Development Facilitation Team (DFT) – Review Comments

DRB Project No: PR-2022-007841 Date: 04/26/2023 Agenda Item: #3 Zone Atlas Page: J-13

Application For: SD-2022-00088 – Preliminary/Final Plat (DHO)

CSI - CARTESIAN SURVEYS, INC. agent for **CARLA CALETTI** requests the aforementioned action(s) for all or a portion of: **LOTS 2 and 3, SUBDIVISION OF LOT 13 OF NAVAJO ADDITION** zoned **R-1A**, located at **1125 12TH ST NW** between **SUMMER AVE NW** and **SAWMILL RD NW** containing approximately **0.1876** acre(s). **(J-13)**

**Plat for
Lots 2-A and 3-A,
Subdivision of Lot 13 Navajo Addition
Being Comprised of
Lots 2 and 3,
Subdivision of Lot 13 Navajo Addition
City of Albuquerque
Bernalillo County, New Mexico
March 2023**

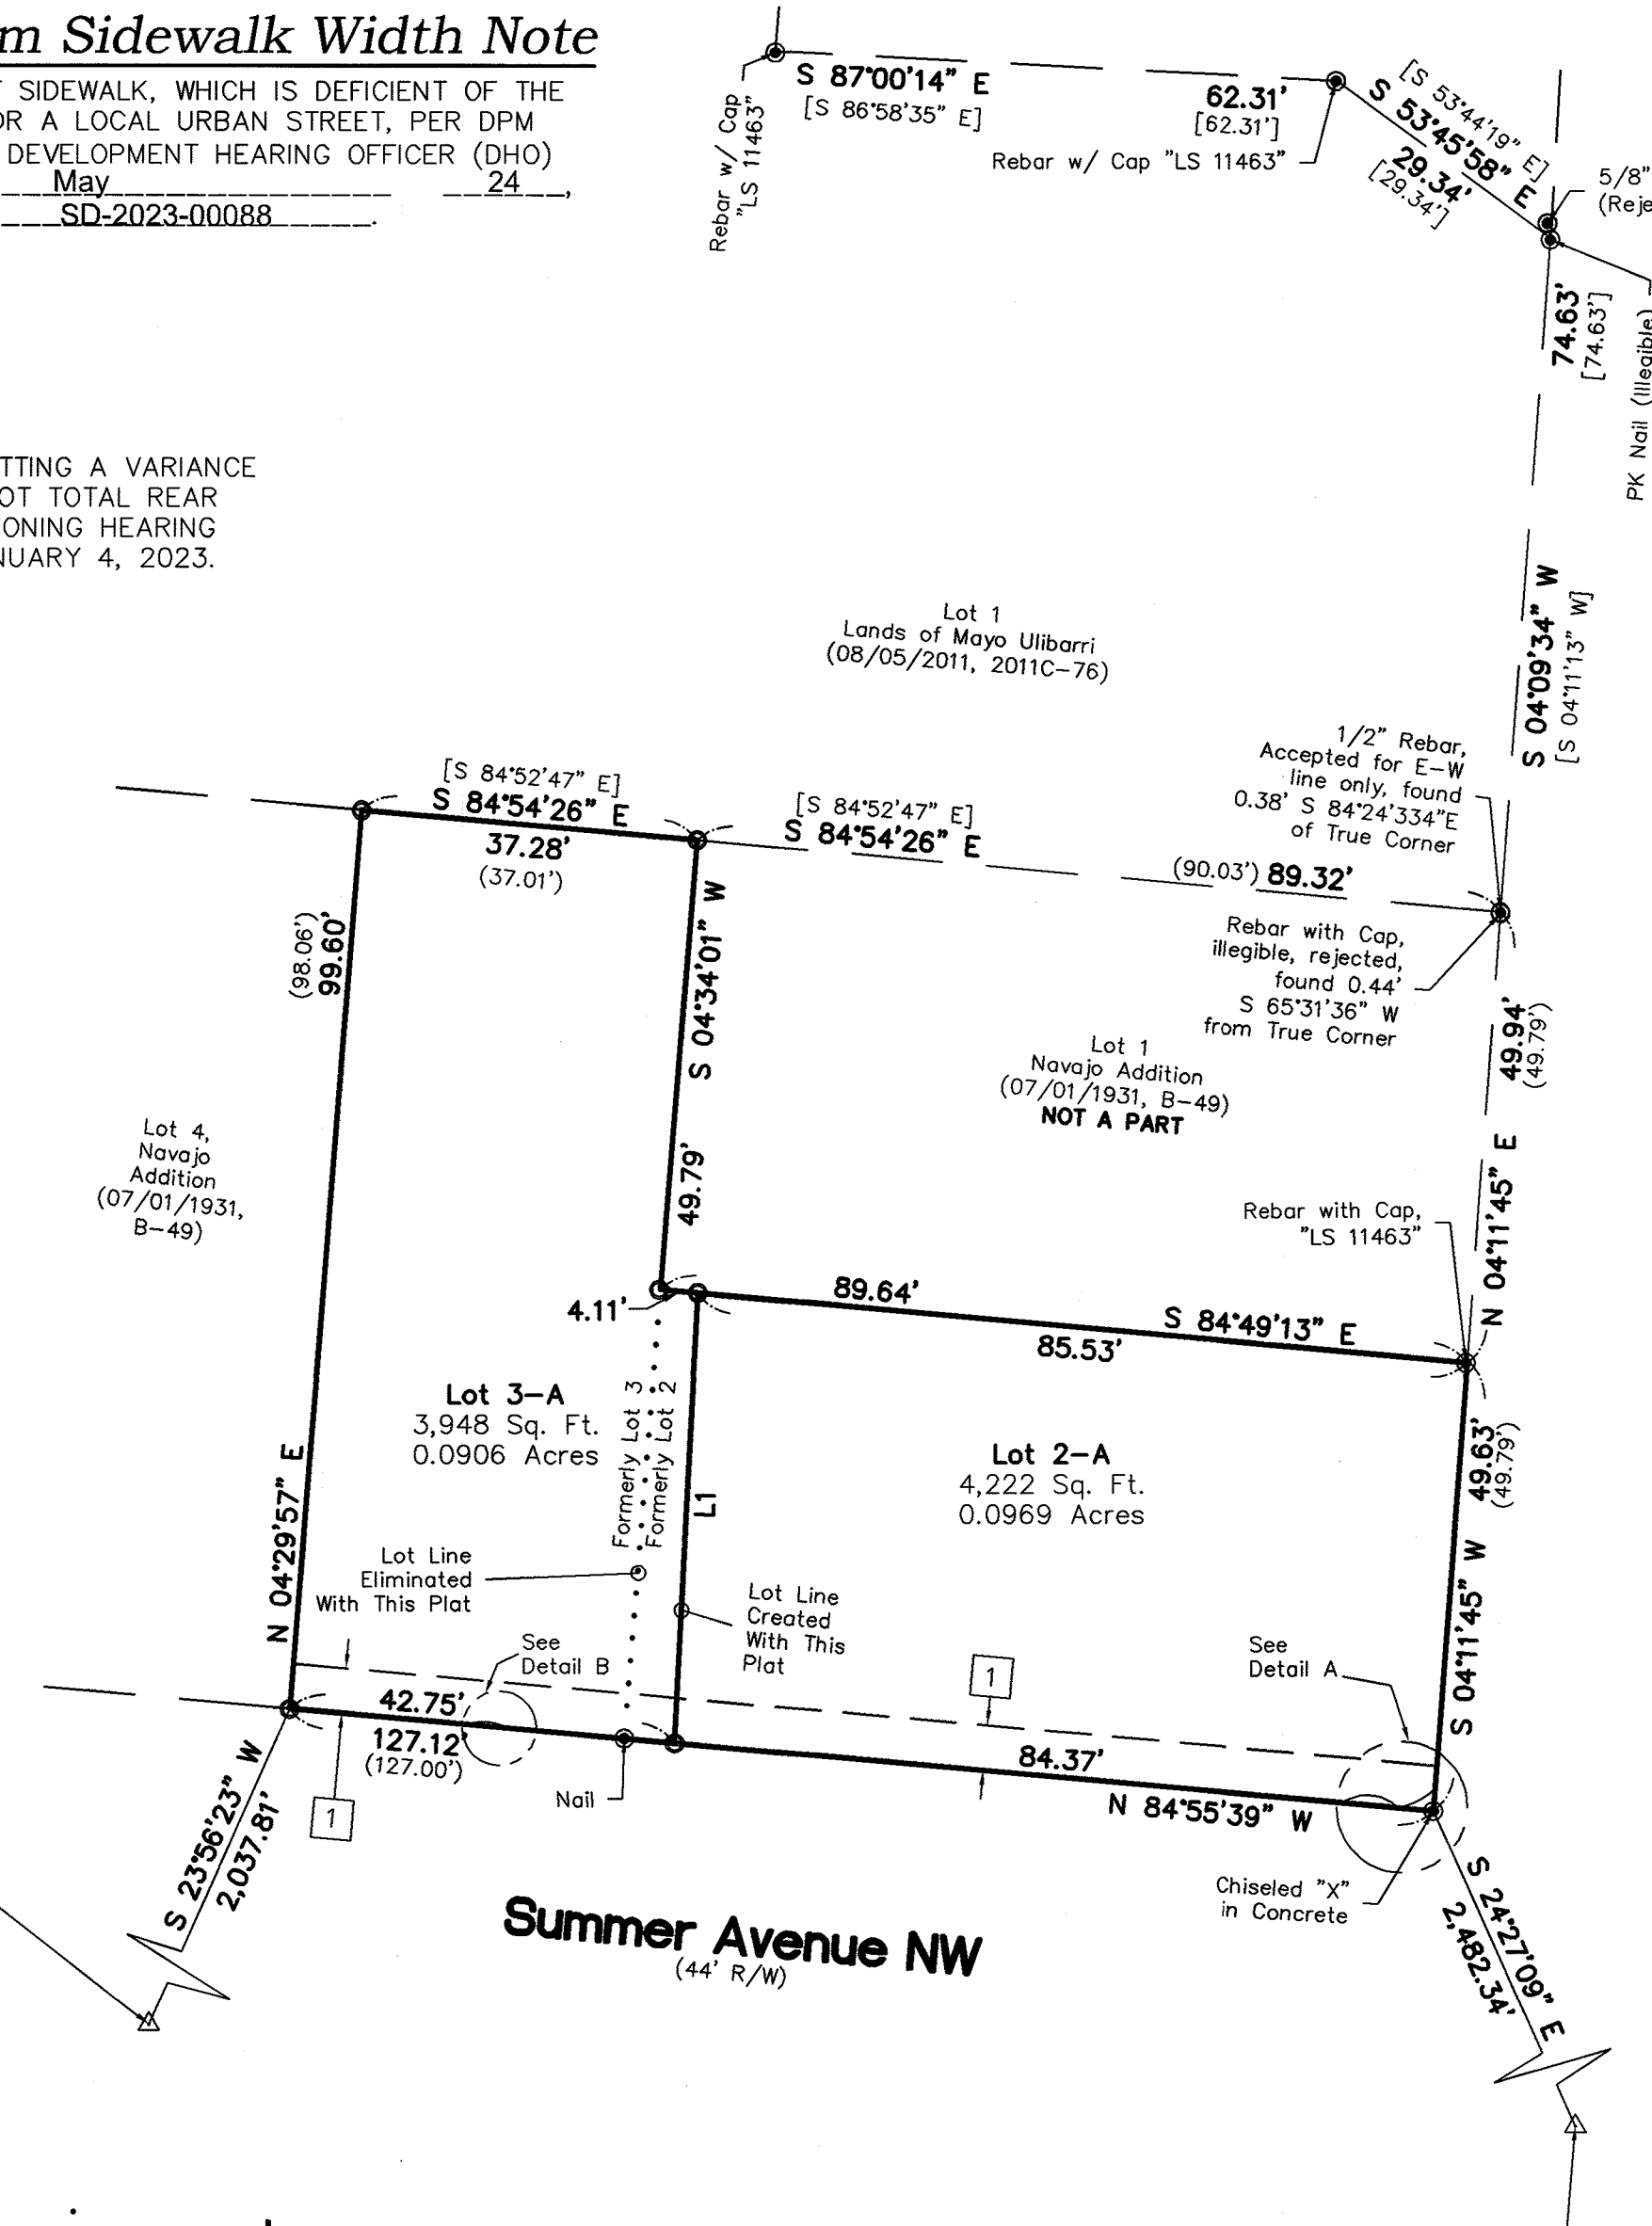
1. Transportation has no objection to the lot line adjustment.
2. Your justification letter for allowing sidewalks to remain existing width made some assumptions which need to be addressed. The letter stated that 4' sidewalk meets ADA which is only works if there is 4' clear around any obstructions and that there are 5' passing area spaced at regular intervals, which is why the City typically requires 5' minimum. There are several obstructions in the sidewalk along Summer which narrows the ADA pathway to less than 4'. Please provide a 4' clear pathway around all obstructions. The passing zones I can waive as the farthest they are allowed is 200' which is longer than the frontage on either road.

- The project & application number must be added to the Plat prior to final sign-off by DFT staff should the Plat be approved by the DHO.
- *Per Table 7.2.29 from section 7 of the DPM:*
12th St is a Major Collector. Requires a 6ft Sidewalk & 5-6ft landscape buffer.
Summer Ave is a Local Street. Requires 5ft sidewalk & 4-6ft landscape buffer.
*Please confirm compliance, or waiver request, or DHO determination request?
- Please confirm if re-plat will include IL-infrastructure list and financial guarantee with DRC?

- The storage shed appears to be nonconforming and built in approximately 2010. It appears to be within the street side yard setback and along the property line. Permit clarification may be needed for the accessory structure. Check with Code Enforcement and/or Building safety to clarify if additional approvals or modifications are needed.
-
